**From:** Andrew Wood <Andrew.Wood@arun.gov.uk>  
**Sent:** 04 November 2019 15:59  
**To:** [REDACTED]  
**Cc:** Planning.Responses <Planning.Responses@arun.gov.uk>  
**Subject:** FW: White Cottage, Walberton (WA/22/19/PL)

**From:** Jason Davies [REDACTED]  
**Sent:** 01 November 2019 13:14  
**To:** Sarah Burrow <[Sarah.Burrow@arun.gov.uk](mailto:Sarah.Burrow@arun.gov.uk)>  
**Cc:** Andrew Wood <[Andrew.Wood@arun.gov.uk](mailto:Andrew.Wood@arun.gov.uk)>; Planning <[Planning@arun.gov.uk](mailto:Planning@arun.gov.uk)>  
**Subject:** White Cottage, Walberton (WA/22/19/PL)

Pit to be 2 x 1.5 x 0.8m deep

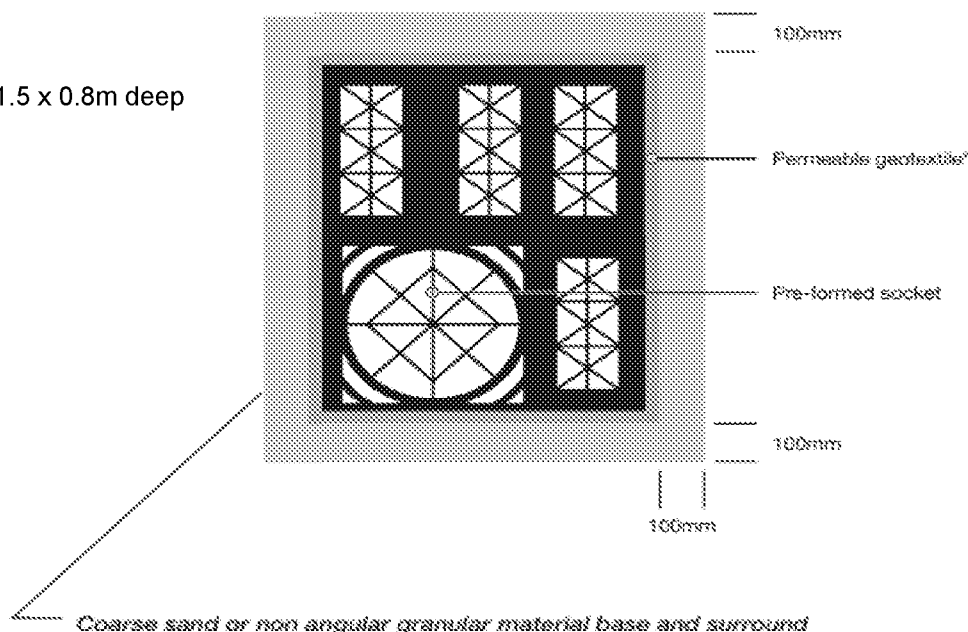
The applicant will need to supply an updated drawing with soakaway details and levels to reflect the correct sizing and depth below ground level. Please can they also raise the incoming pipework to the soakaway to the highest level possible.

Drawing B16b August 2018 Scale 1:20 & 1:100 @ A1
Building Regulation Drawing - Externals Plan

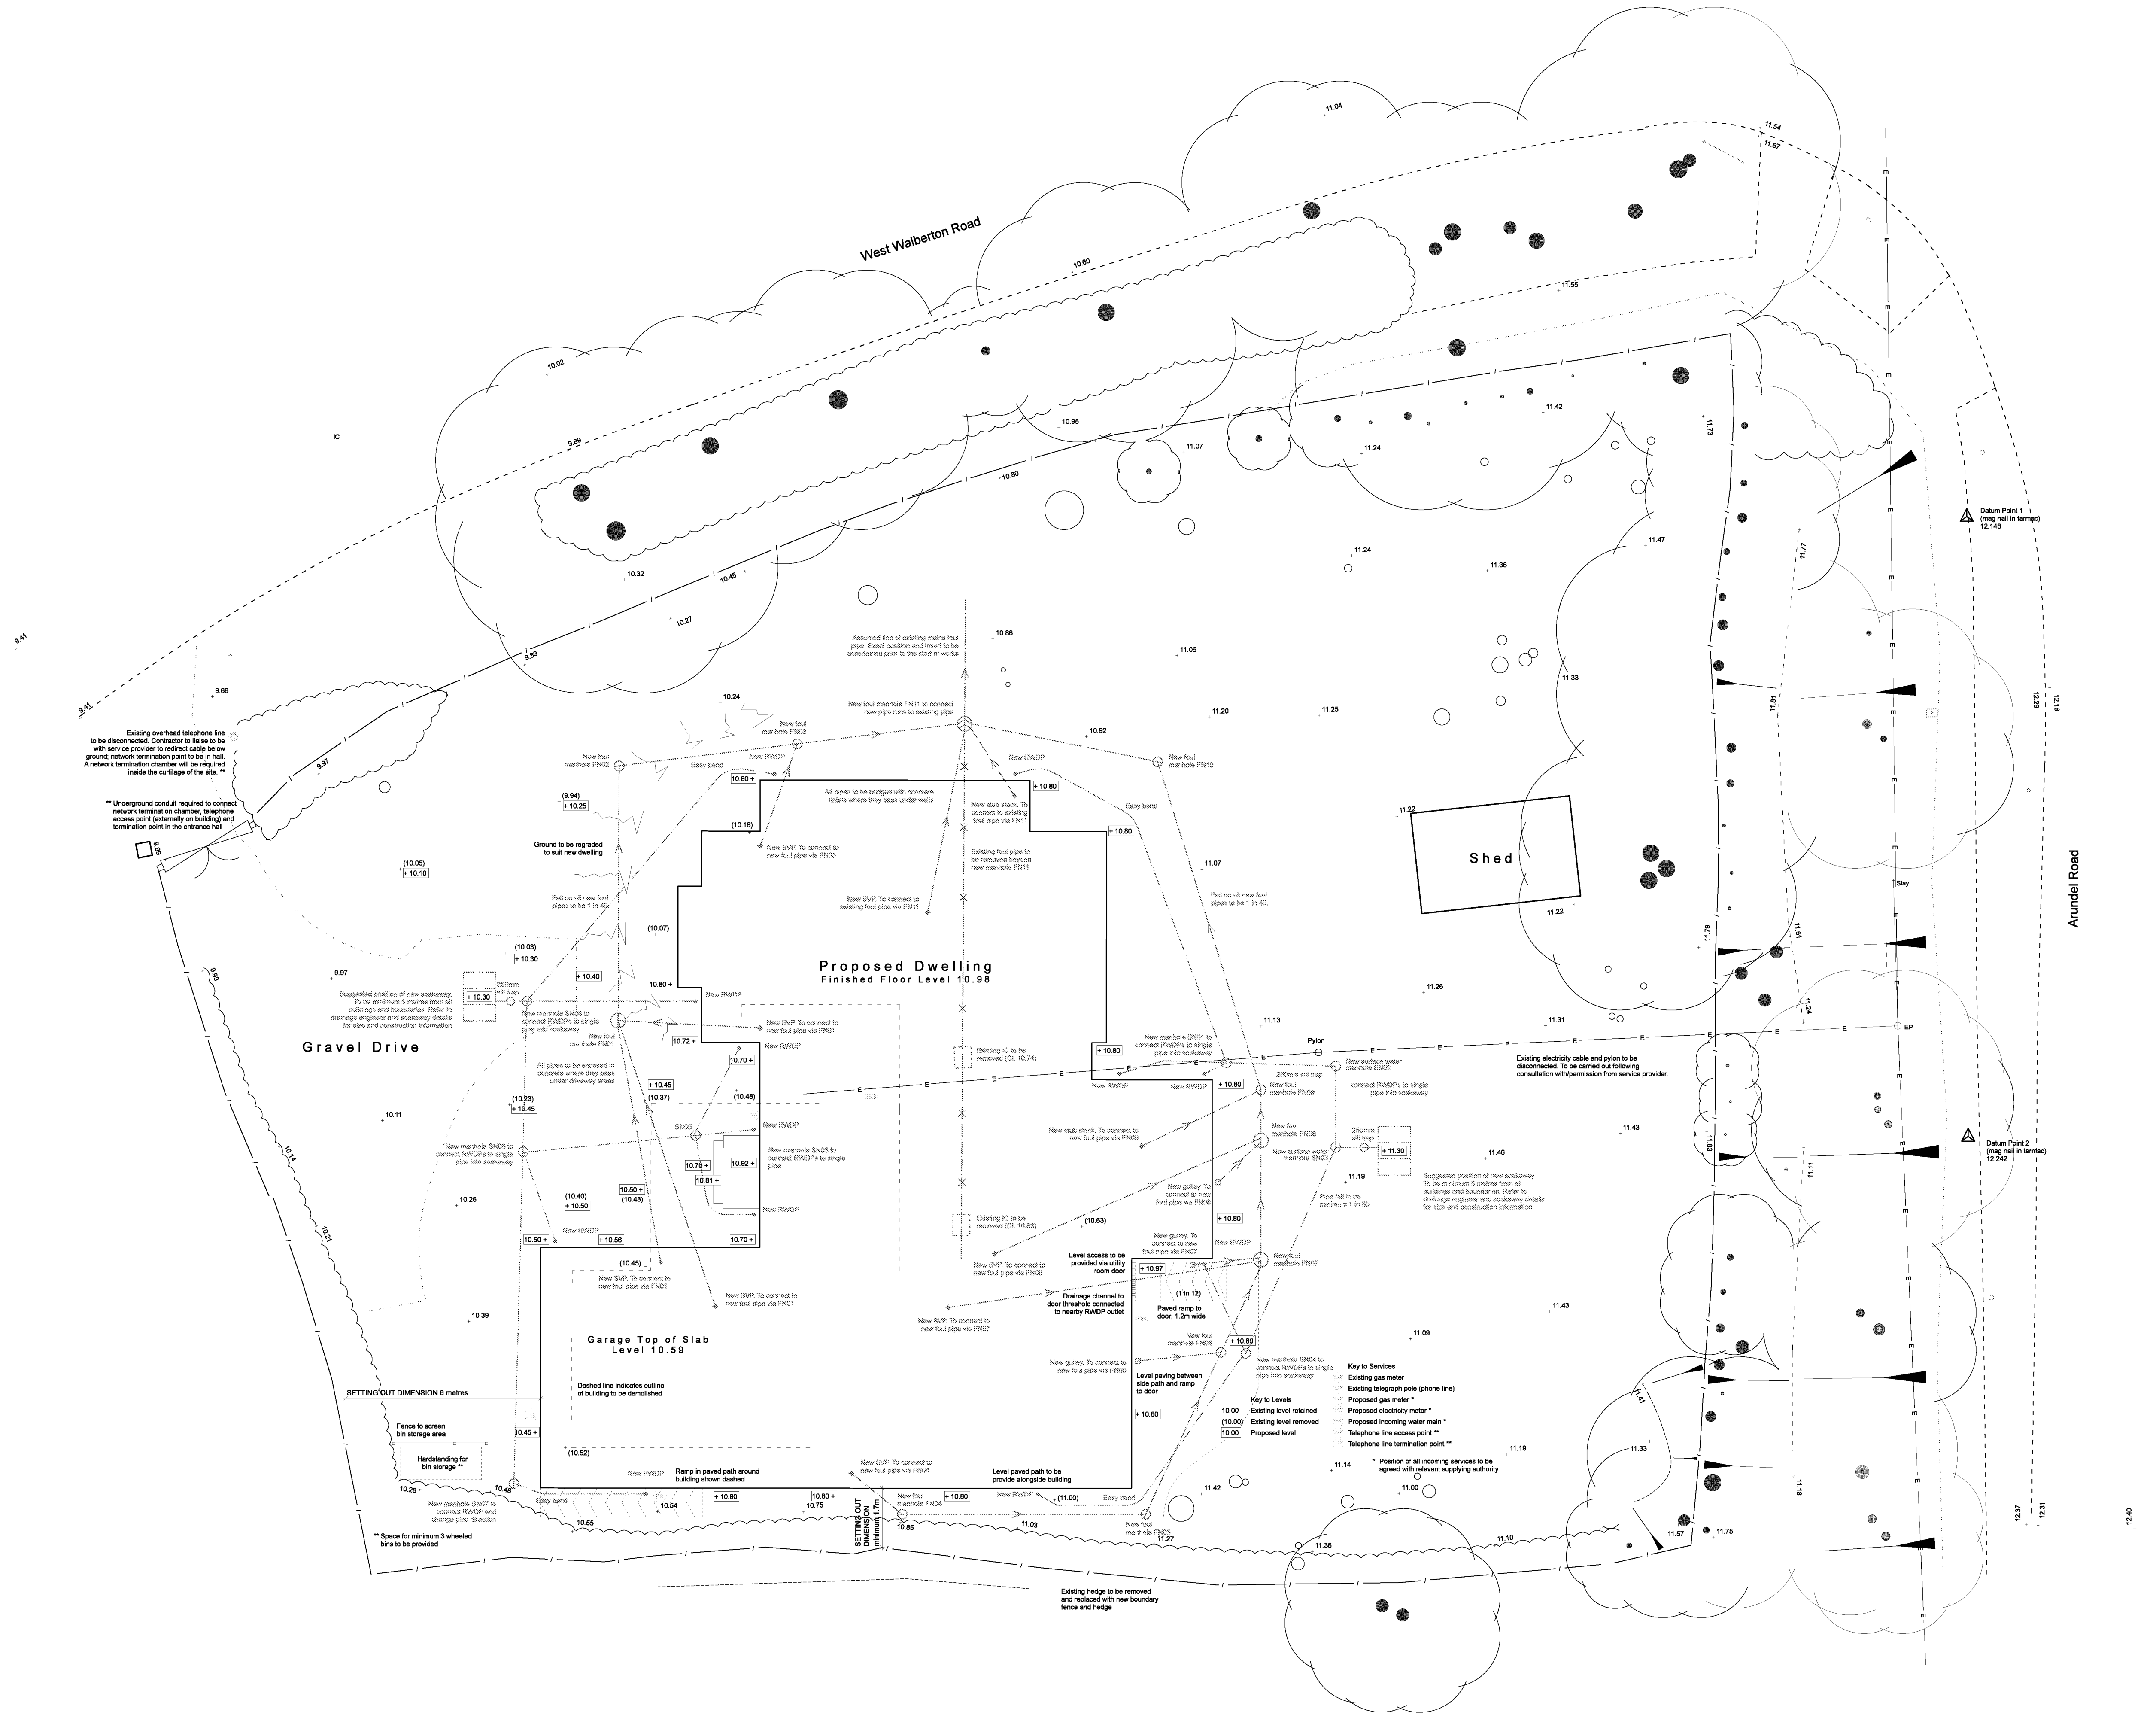
I have had an unexpected break from what I thought I'd be doing and have taken a look at this application. I am satisfied that the calculations (despite still containing minor errors) now provide an infiltration structure of adequate size. However this soakaway design will have to be updated on the drawing before I can recommend that Laura's condition be removed. This should be a fairly straightforward exercise.

This should be uploaded to the planning portal along with the Soakaway Calculations (Revision E) and the silt trap detail (please be clear that they are proposing to use the mini-silt trap).
